19/01643/DISC White Post Road Banbury

The archaeological written scheme of investigation (WSI) submitted to meet condition 25 does not meet the requirements of our design brief and is not acceptable to meet condition 25.

Richard Oram
Planning Archaeologist

Figure 2: Phased Excavations

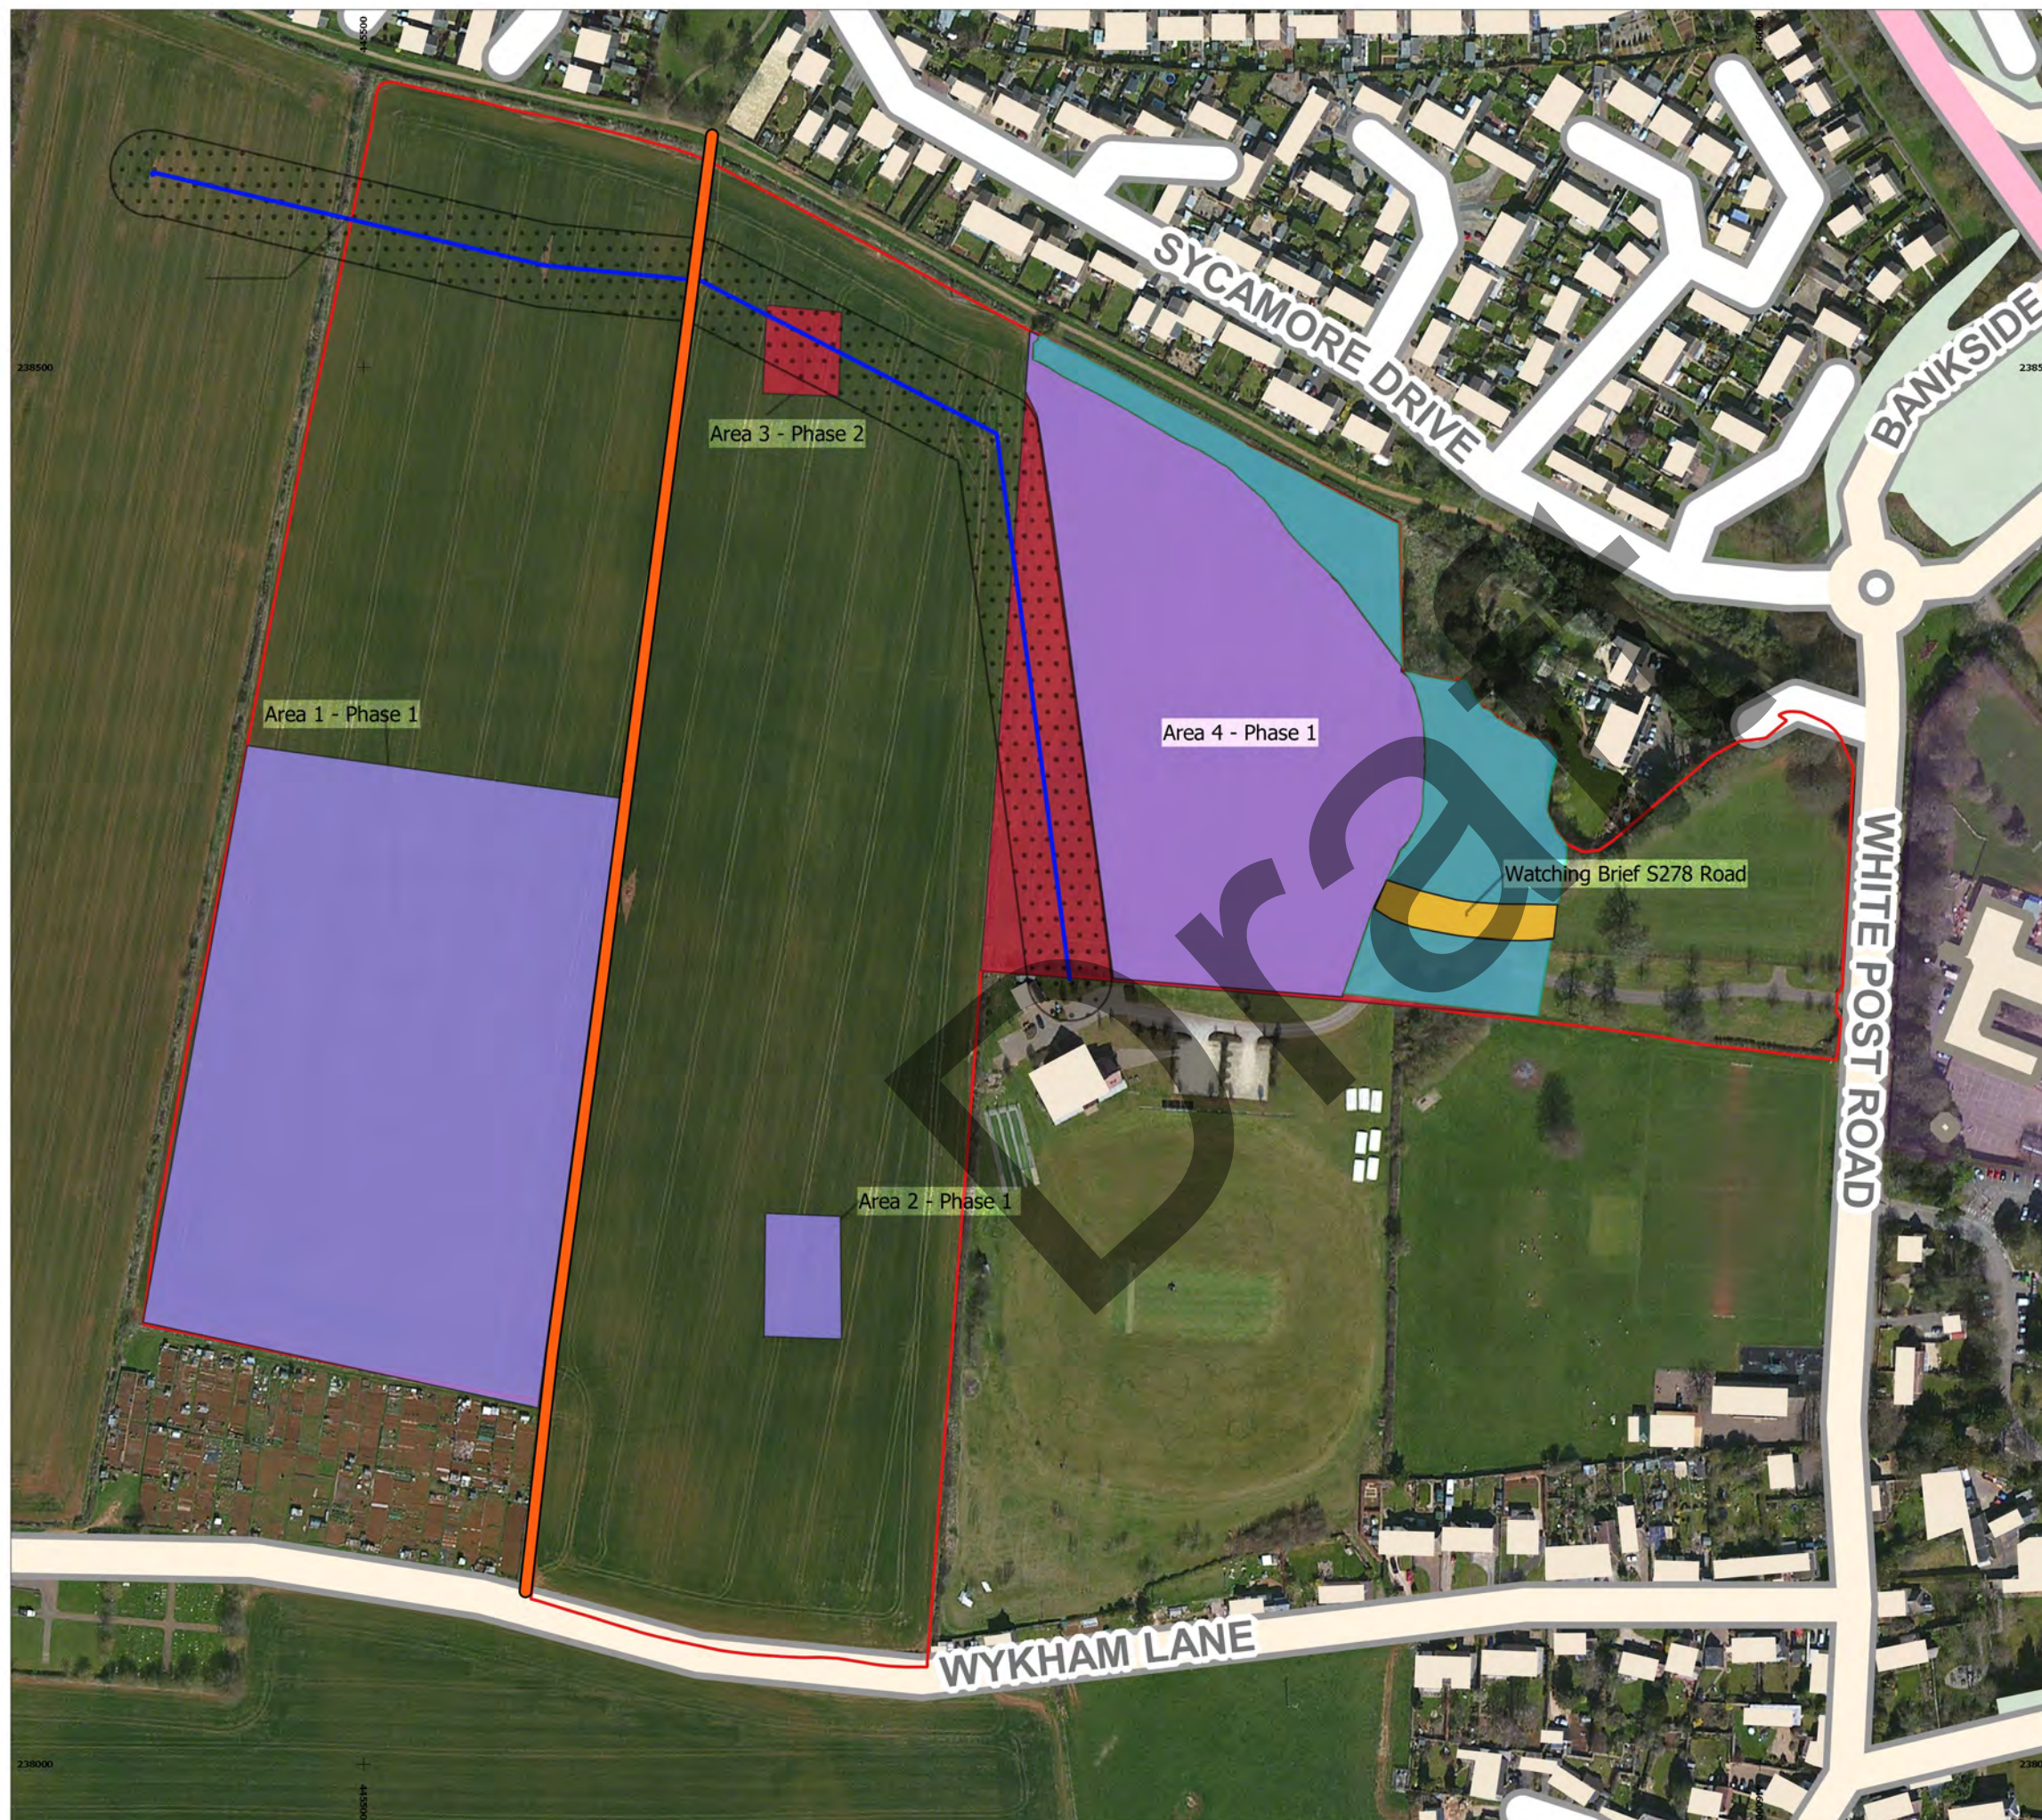
The WSI does not include any excavation of green space areas associated with the application on the eastern side of the site. These areas however contain proposals for tree planting and other landscaping that would impact on archaeological features and as such a programme of archaeological mitigation will be required in these areas as set out in our design brief.

The WSI also includes an archaeological watching brief for a roadway within this area. A watching brief would not be an appropriate form of mitigation for this roadway and our brief specified that this would need to be included within the excavation area for the green space.

A revised WSI based on our design brief should be agreed with ourselves and then submitted with this discharge application to meet condition 25.
